HDM Review (in red text) on 24/11/25, of previous HDM comments provided in email of 02/09/25

Harron/Optima response 12/12/25 (purple text)

Based on Netherton Revision C Site Layout (Construction), appended to email response to Highways.

### S38 Comments Summary

INSET 04

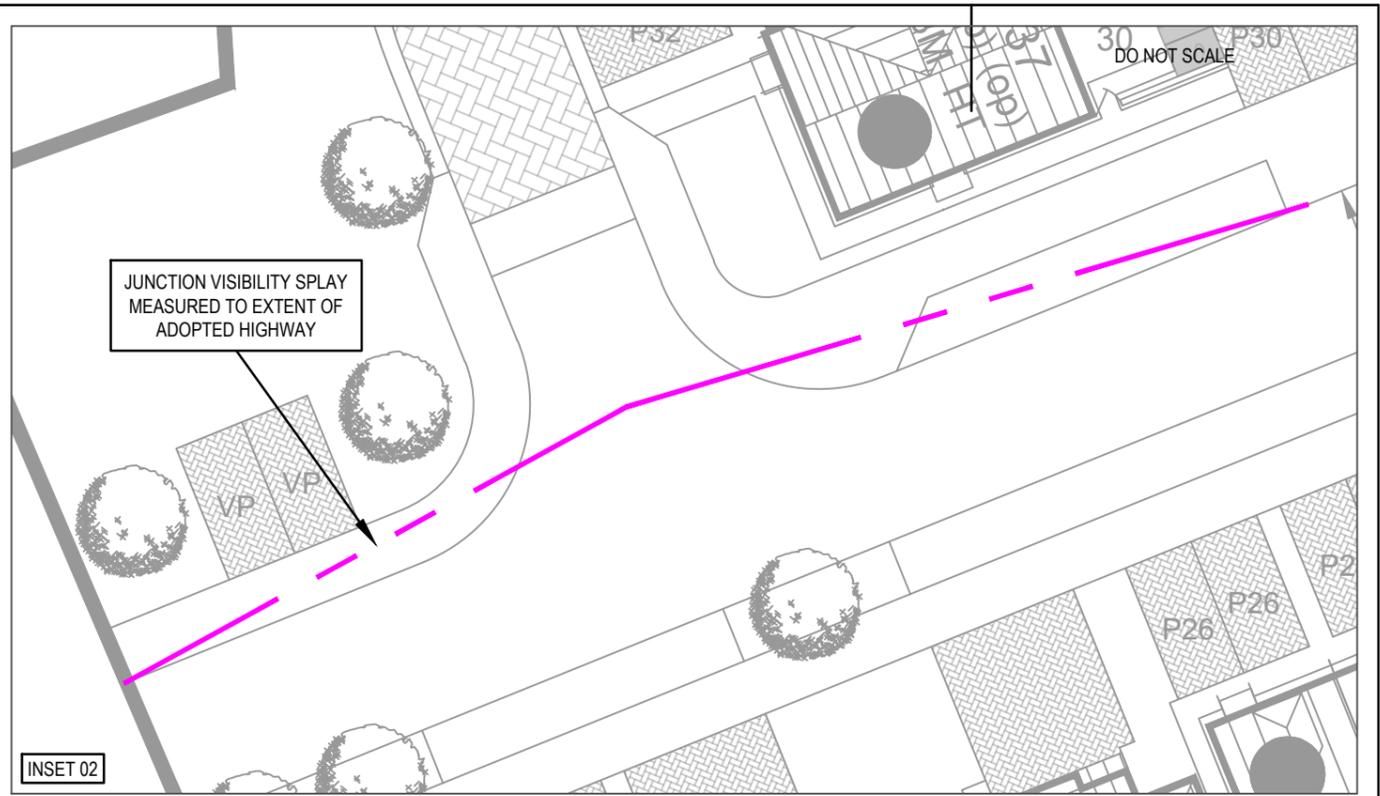
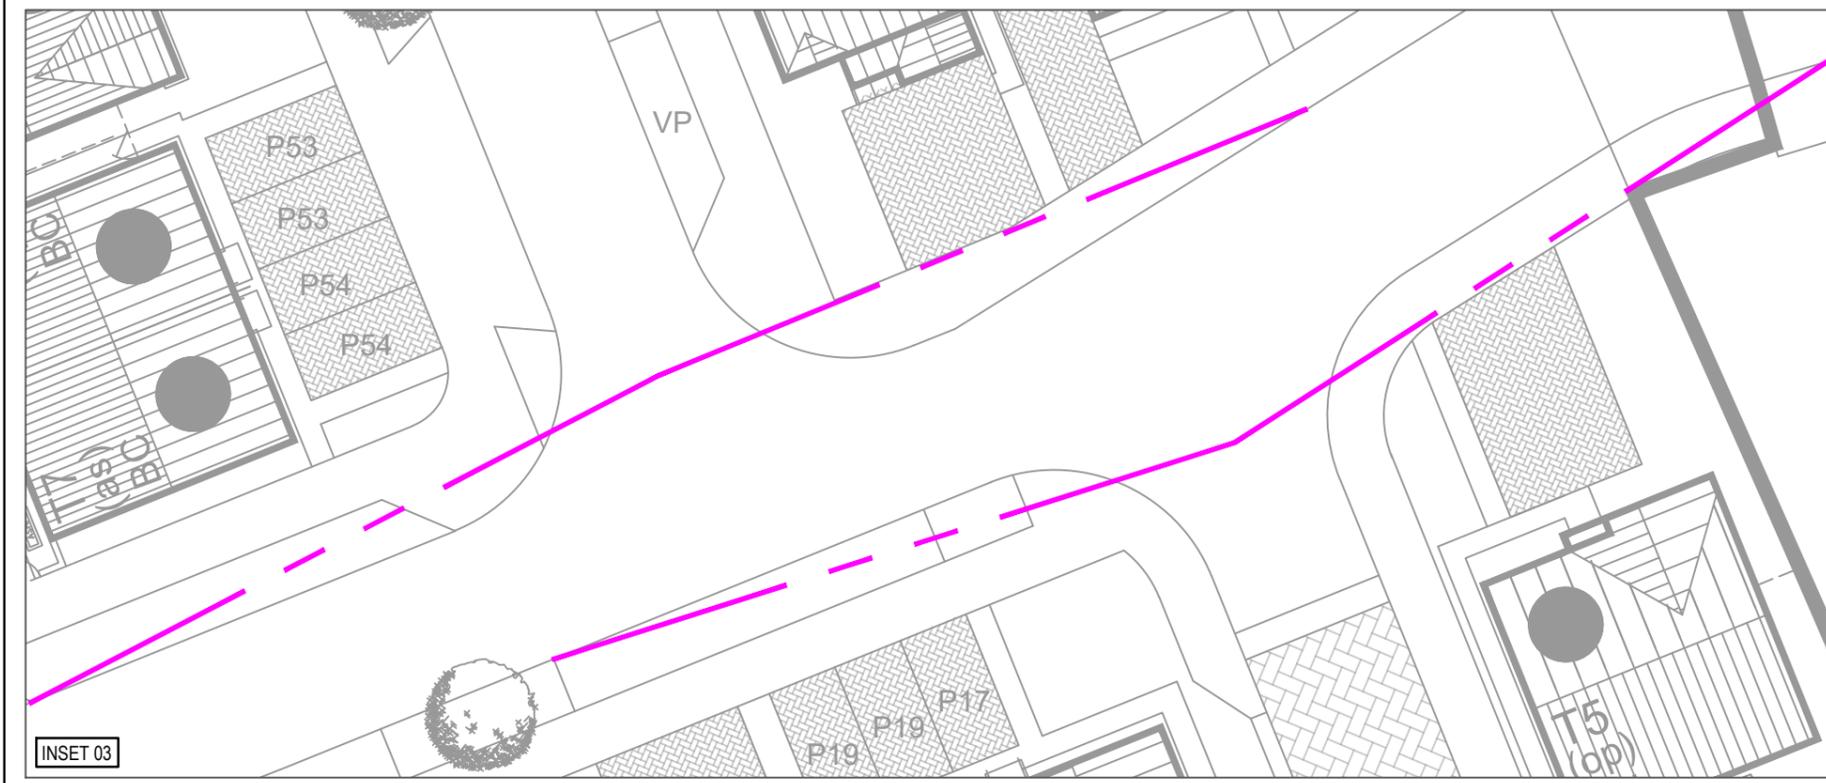
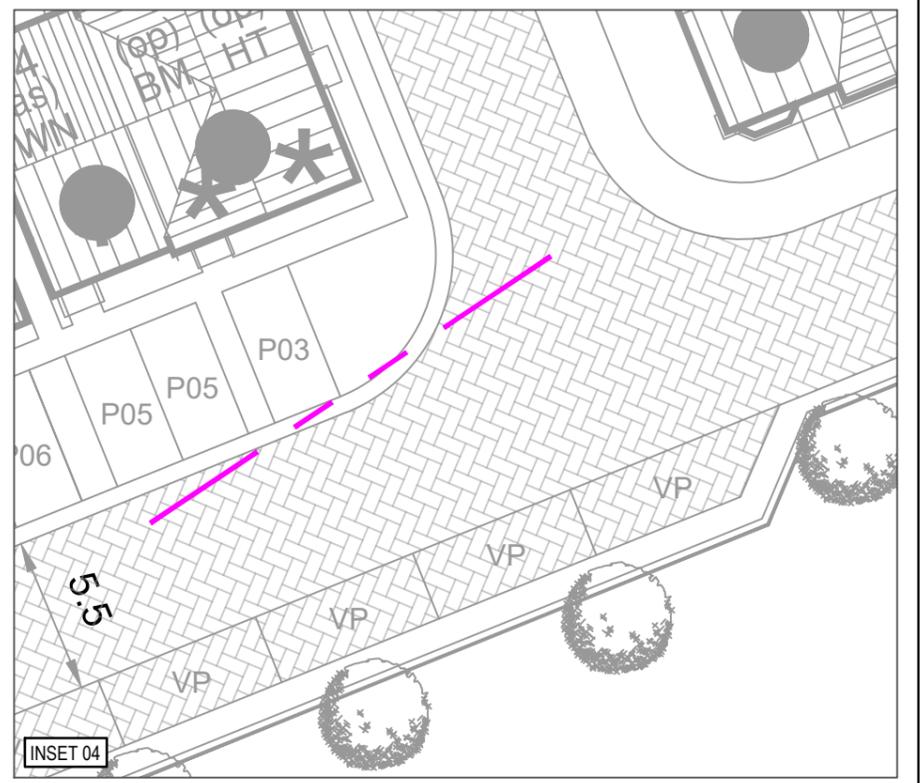
**Inset 4 on drawing 25041/IN/01 suggests a visibility splay of 2.4x25m is available at the junction of the shared surface street. However, it is clear that this is not correct and needs to be reviewed. It is noted that as this is a shared surface street, a splay of 2.4x23m can be accepted (but not 2.4x17m, as mentioned by Optima to Jon Beeson in their email of 17/10/25, which will not be accepted by the S38 Highway Adoption Team). We have relocated the Parking Bay for Plot 3 and re-drawn the bend to ensure the vis splay is outside of private ownership. We note that a 2.4m x 17m visibility splay for a 15mph speed limit is considered acceptable within the design guide for a shared surface street however a 2.4m x 23m splay has been shown and measured to the nearside wheel track (which is advised in Manual for Streets 2) and therefore can be achieved within the adopted highway.**

As per the earlier comment, this issue has not been addressed. A splay of 2.4x23m needs to be demonstrated that is contained within the adoptable highway. As previous comment; site layout updated to ensure vis splay within highways ownership.
- The shared private drive serving plots P09-P11 is only 4m wide, which is below the minimum width of 4.5m that is required for the first 5m, in accordance with the Kirklees Highway Design Guide SPD.

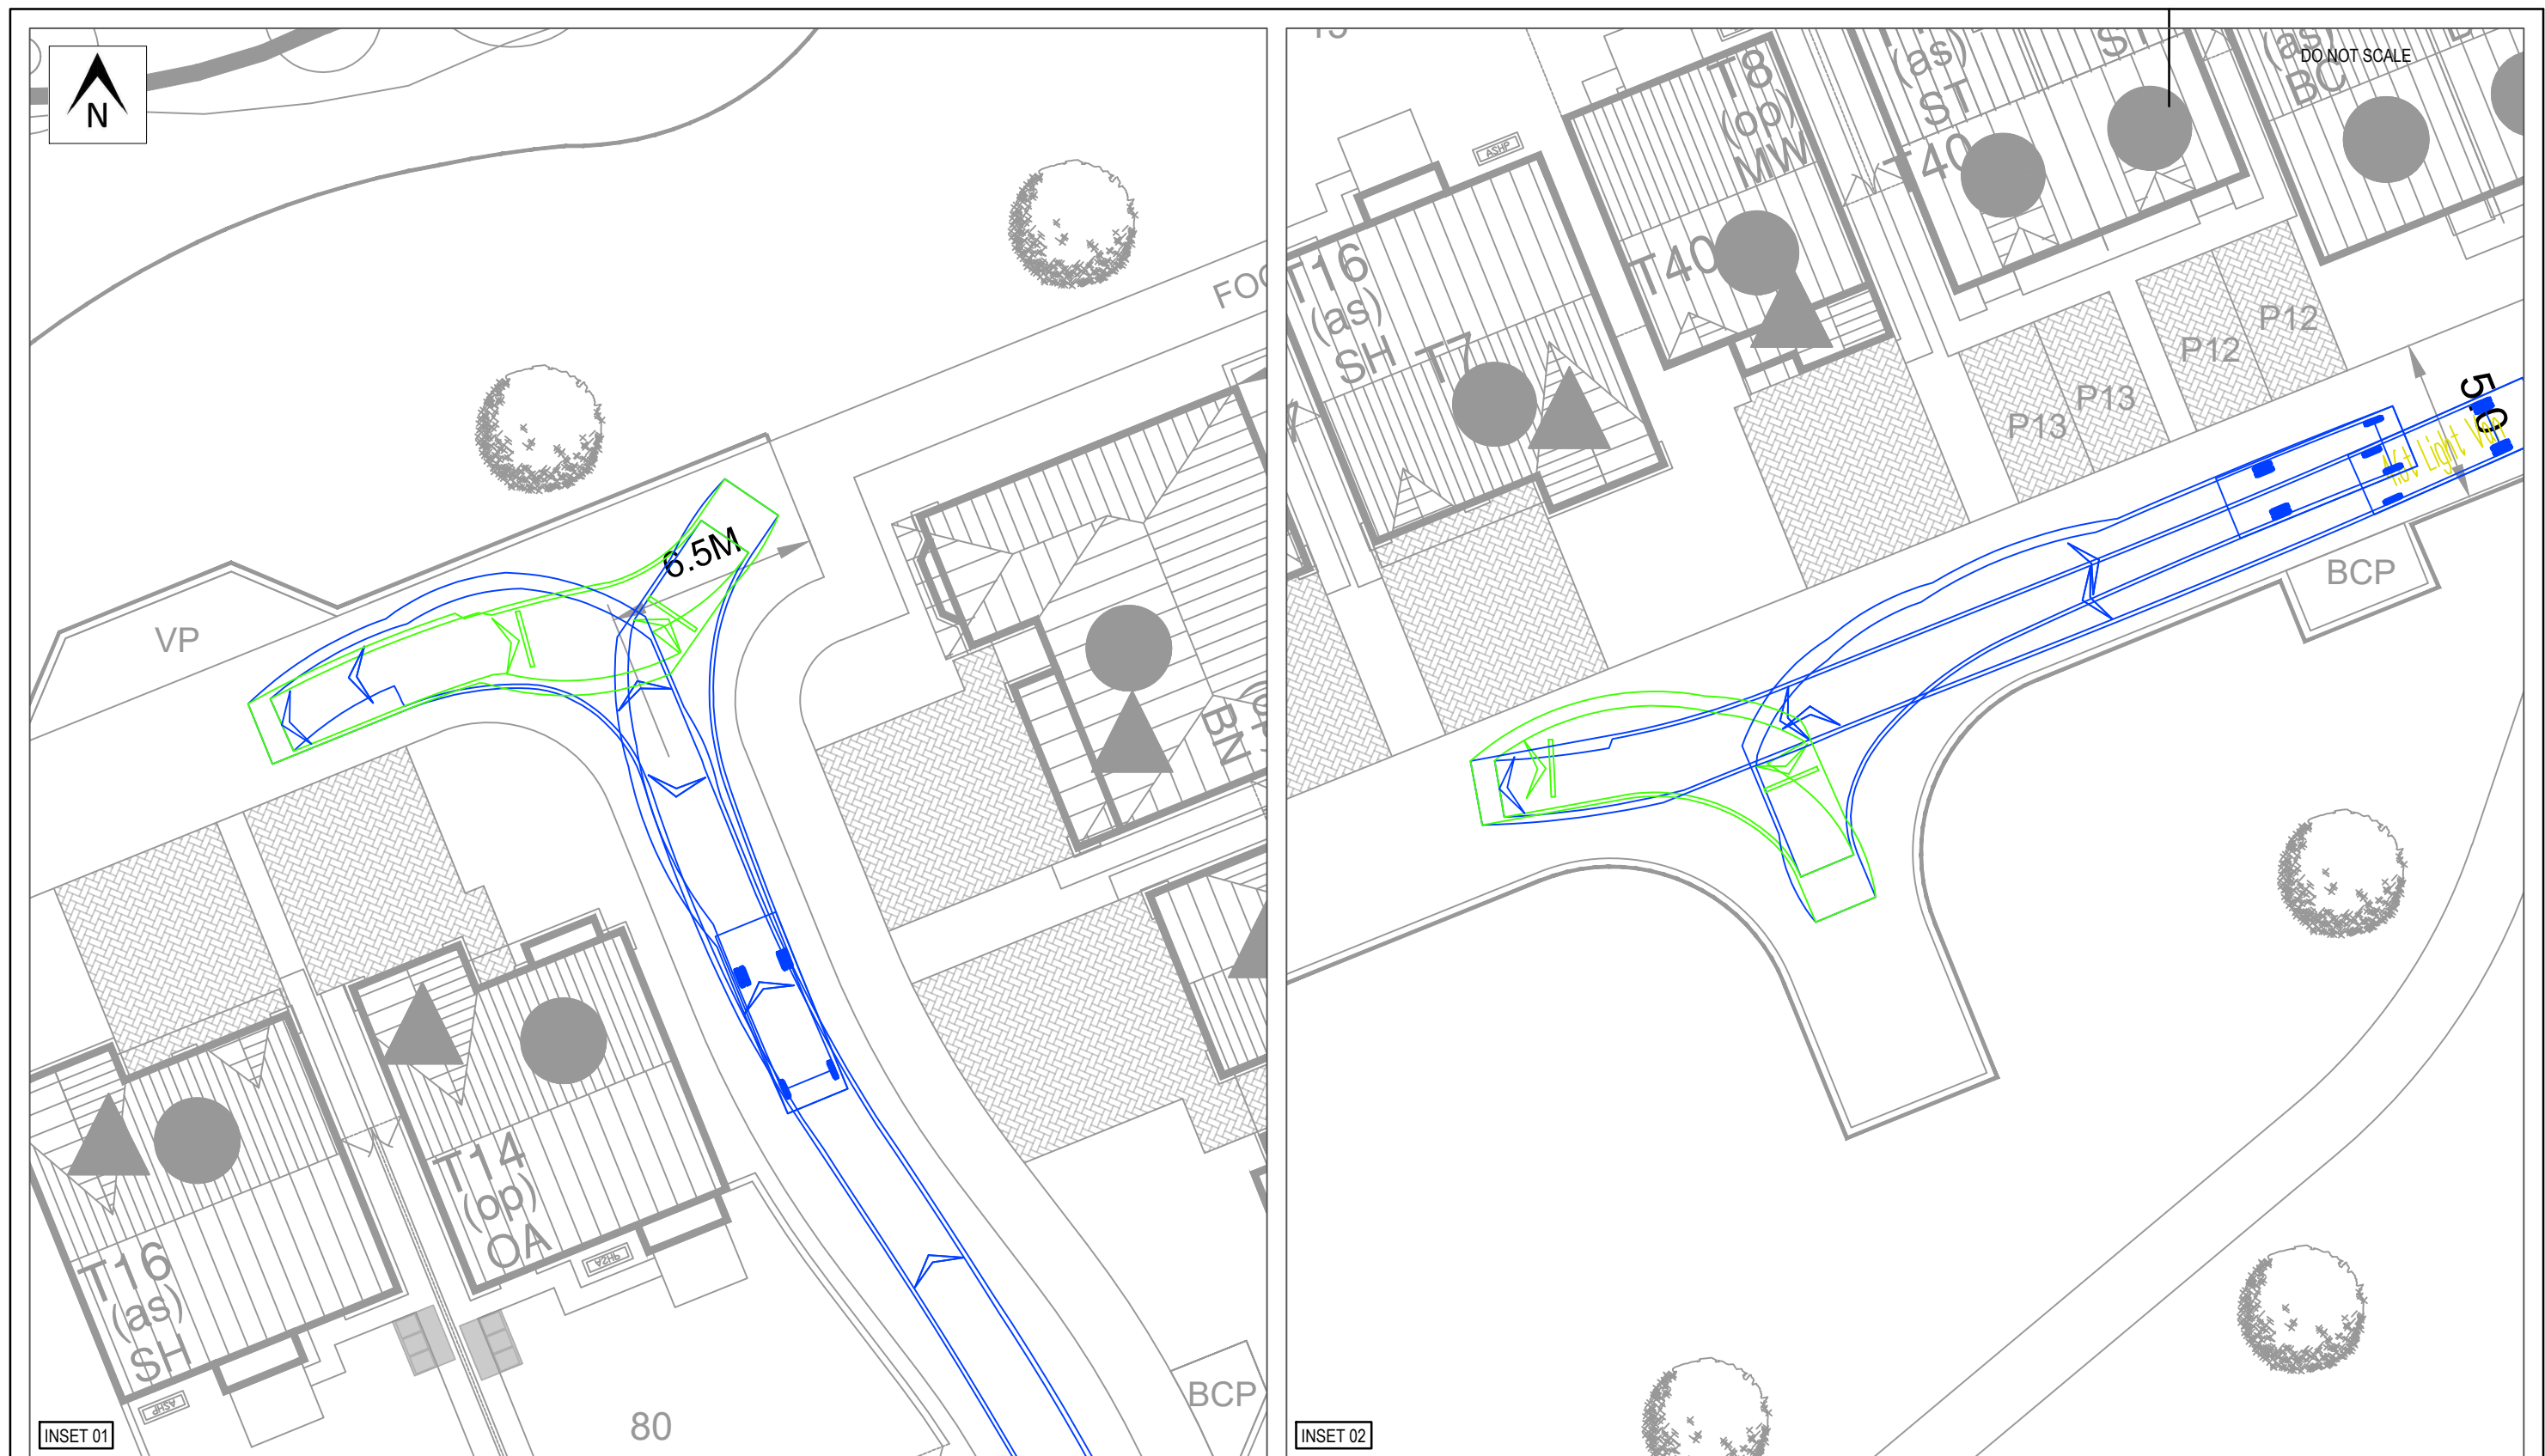
- Swept path analysis is required for the full site layout, confirming the Councils design refuse vehicle can pass a car throughout the layout, including at all bends (e.g. to ensure parked or passing cars do not block access for the refuse vehicle).  
The swept path analysis provided demonstrates that the refuse vehicle cannot pass a car on the bends. This is a specific requirement of the S38 Highway Adoption Team. Therefore, if the applicant is not willing to incorporate the necessary widening, then is likely to present a barrier to adoption. This road has been re-tracked and we are now achieving 7.4m width at the widest point. Updated tracking drawings have been provided which demonstrate a RVC can pass a moving vehicle with a clear distance between the two. Site has been adjusted to suit.

Updated SPA required to confirm that all roads are suitable for adoption. Please see appended to email.
